# ENG-SF22025-R4-Plat.pdf Markup Summary

CIVIL CONSULTANTS, INC.
 212 N. WAHSATCH AVE., STE 305
 COLORADO SPRINGS, CO 80903
 PHONE: 719.955.5485
SHEET 2 OF 6

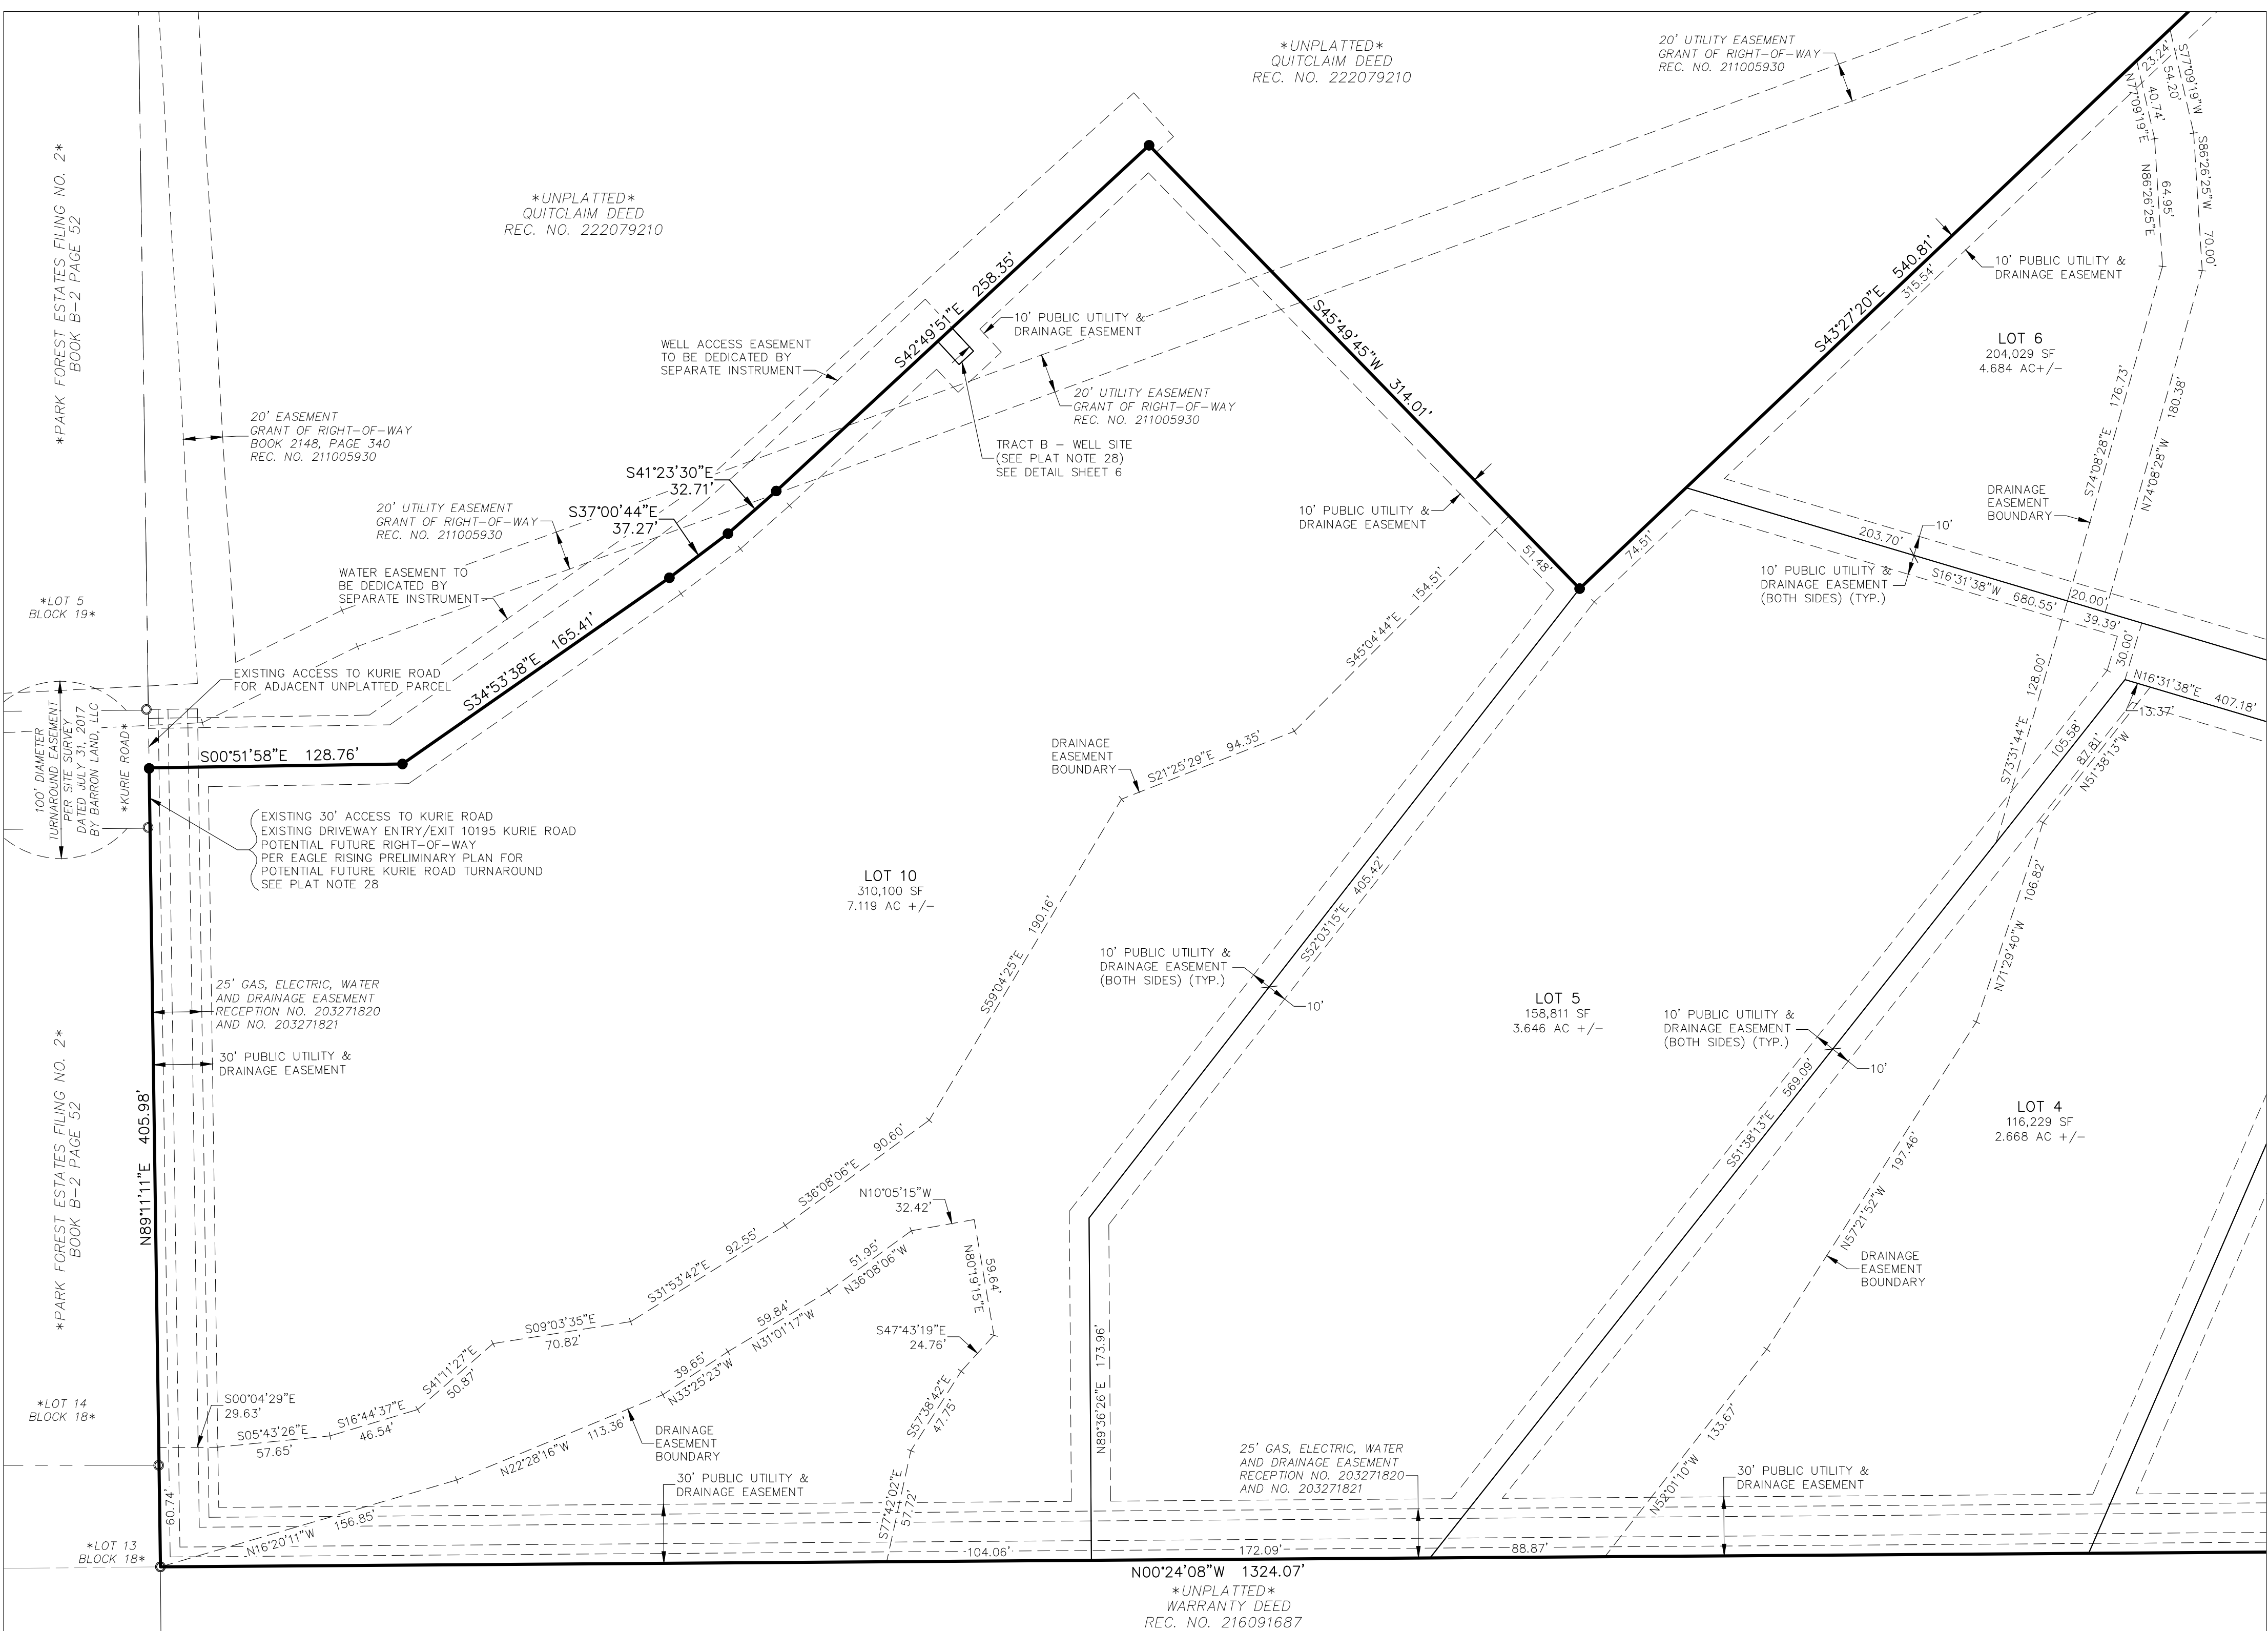
This note is not adequate per LDC Sec. 8.4.4.B which states that either public ROW is dedicated, or land for public ROW is preserved. You must depict the land for dedication or preservation for future ROW, per the discussion staff had with the applicant.

Cul-de-sac ROW needs to be shown per V3 Plat comments.

Right-of-Way Dedication Required. Roads shall be located within a dedicated public right-of-way meeting the requirements of the ECM for the roadway classification proposed. .... In accordance with BoCC policy, the BoCC may allow a disclosure such as "public ROW easement" or "future ROW" to be placed on a plat as an alternative to dedication. If you choose to not provide ROW at this time, and are requesting to instead add a note to call out "public ROW easement" or "future ROW", please add to your LOI to allow the BOCC to make this allowance, also add this call out and the easement area to the plat. A "NEPE" easement document will be required if this option is allowed by the BoCC.

Please provide copy of a construction easement for future emplacement of pipe and outfall F . Note that Staff is reviewing the drainage "permission" letter sent separately to confirm if that is adequate in place of an actual drainage easement. Reference DCM Section 4.8.1, LDC Sections 6.3.5(B)(2) and 8.4.5(G)(2).
